**Anglian Water
Services Ltd**
Lancaster House
Lancaster Way
Ermine Business Park
Huntingdon
PE29 6XU

**Cambridge Waste Water Treatment Plant Initial Response to WW010003-000815
Procedural Decision 10th of August 2023**

Application Ref: WW010003

Figure 1.1: Scope of the draft DCO and the future demolition and redevelopment of the site at Cowley Road

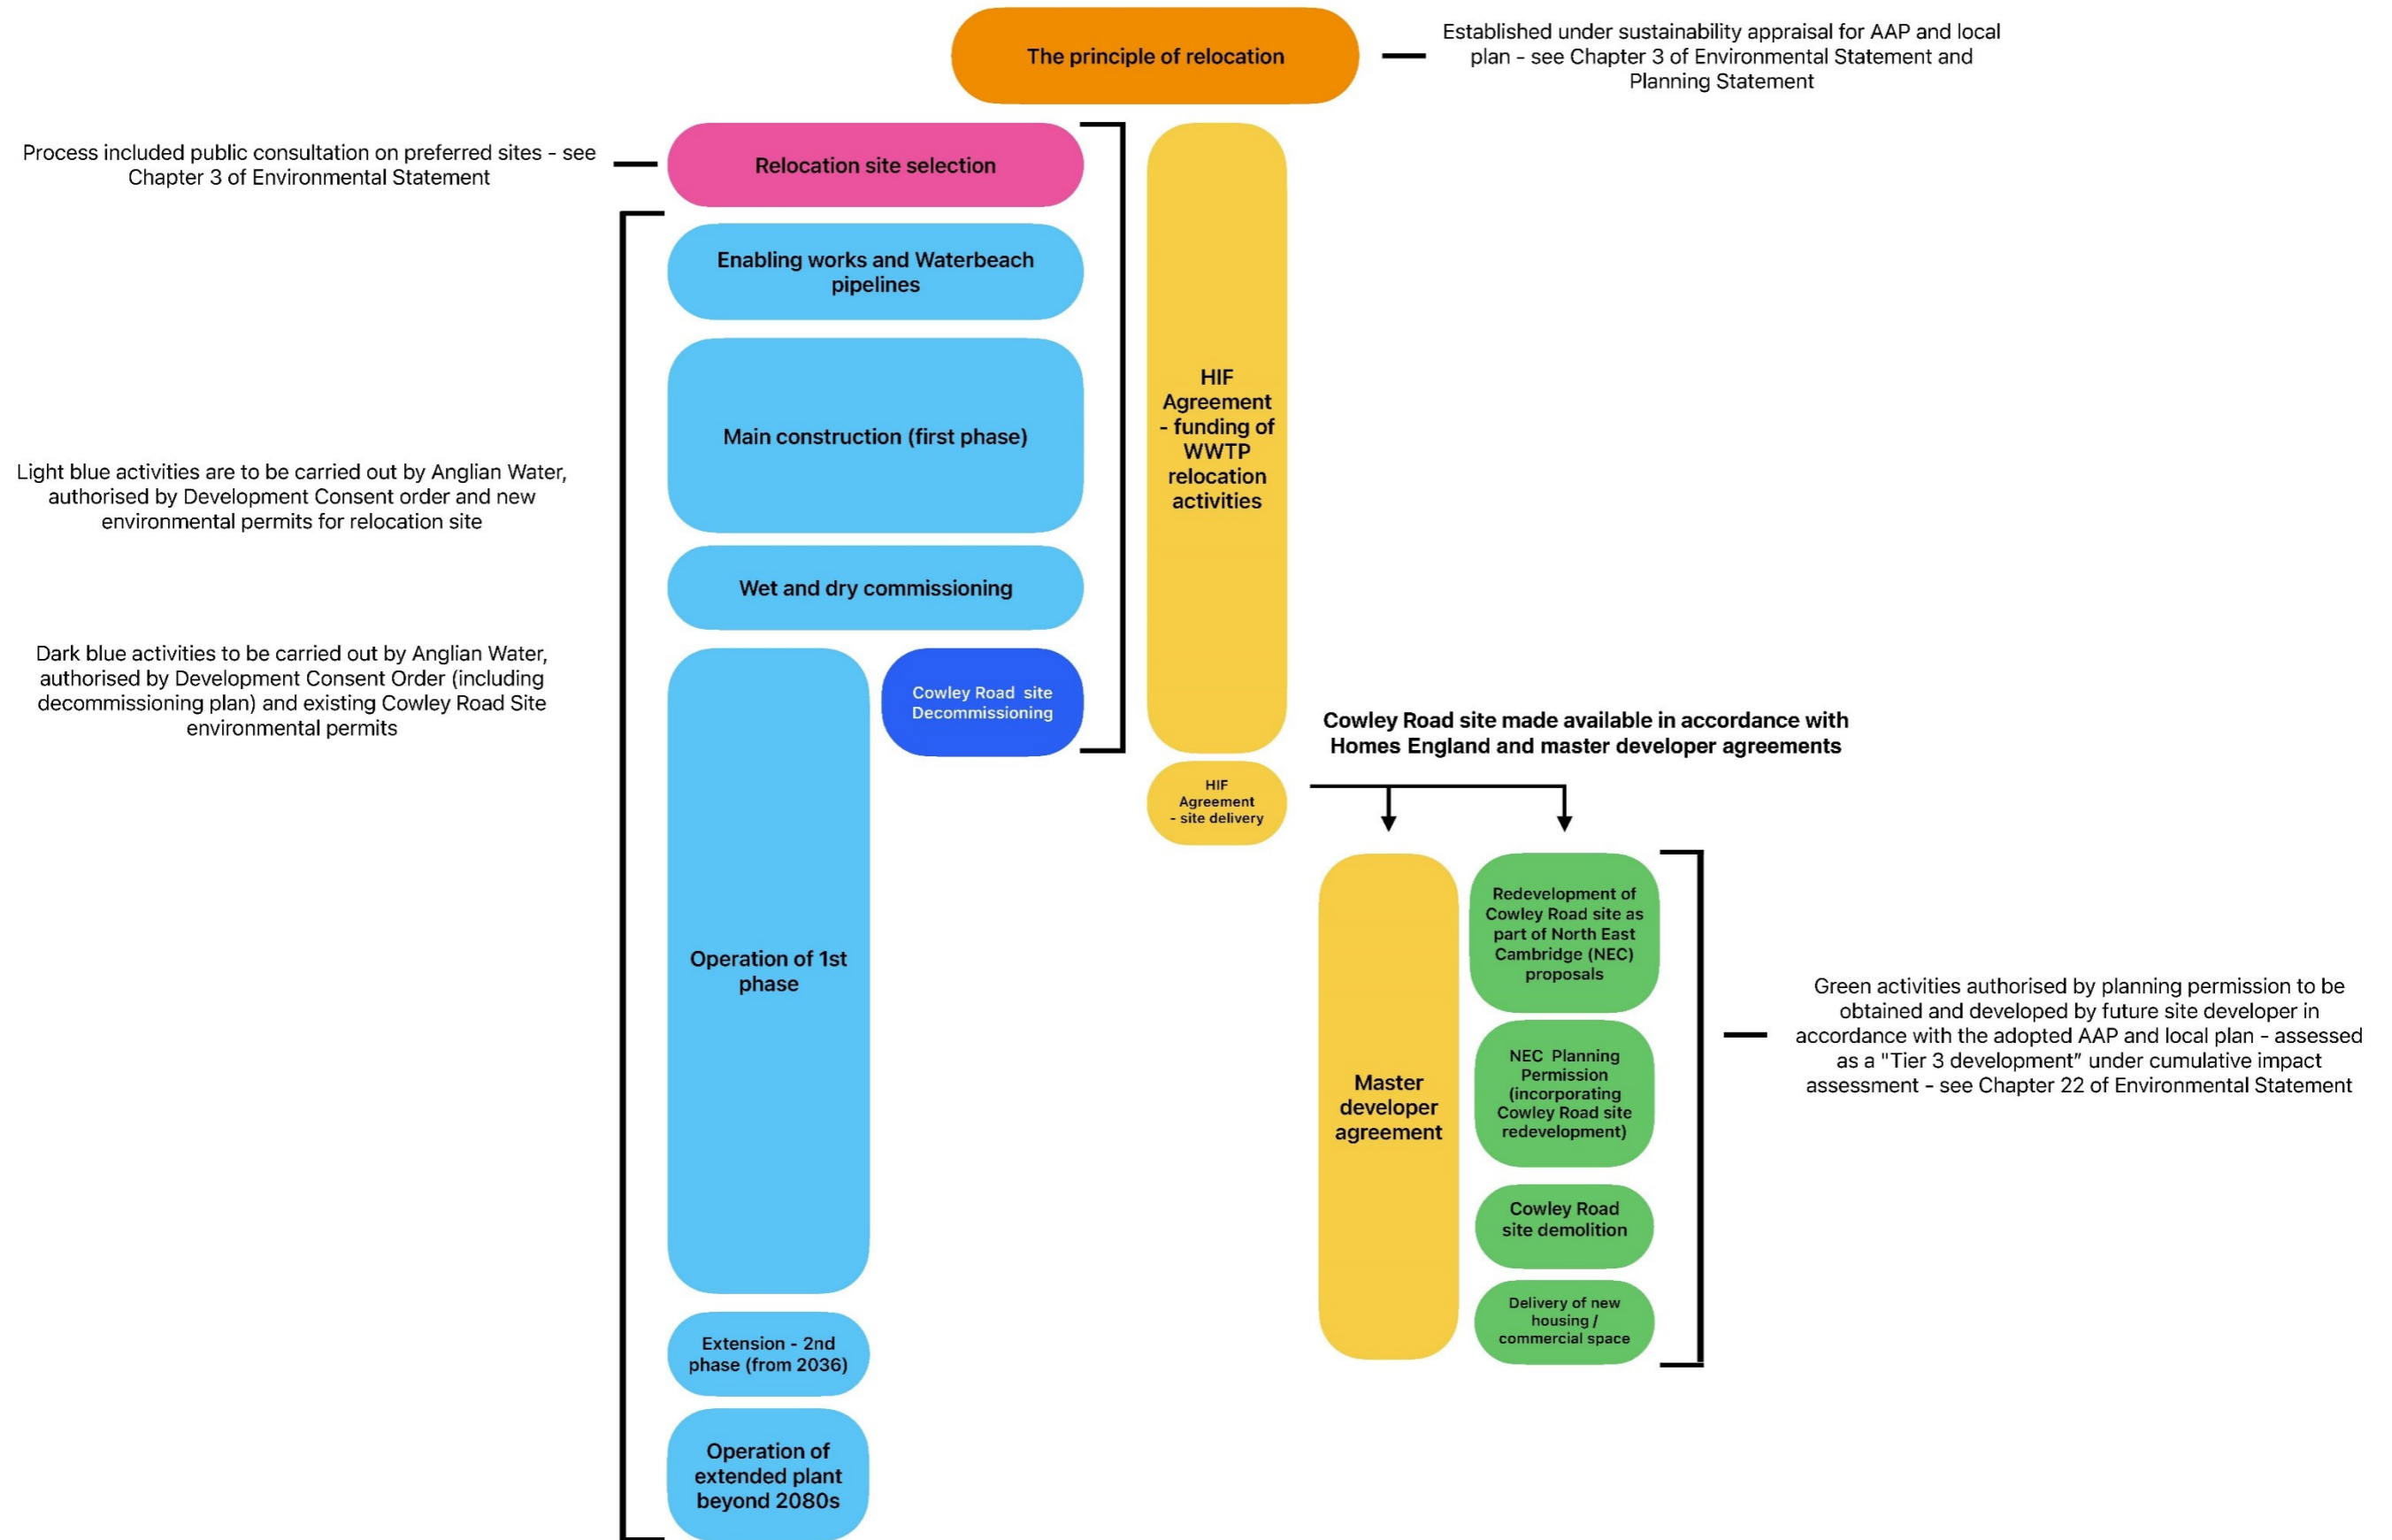
15.a	Statement of Reasons [APP-012]	Figure 1.1 is updated and is resubmitted in this Procedural Decision submission.
15.b	Statement of Reasons [APP-012]	The Applicant notes the comments made and has updated the legislation reference.
16	Biodiversity	<p>The Applicant notes the matters raised and has undertaken a full review of Chapter 8: Biodiversity and associated figures to address the comments.</p> <p>The Preliminary Ecological Appraisal is provided with the Procedural Decision submission.</p>
17	Water Resources	<p>The Applicant notes the comments made and has undertaken a full review of the appendices to address the comments.</p> <p>There are five new reports relating the Land Quality 17b and 18 below (Appendices 14.6 to 14.9) these reports were produced externally and have been secured via password. They are included in this Procedural Decision submission, however, unfortunately we have been unable to obtain fully</p>
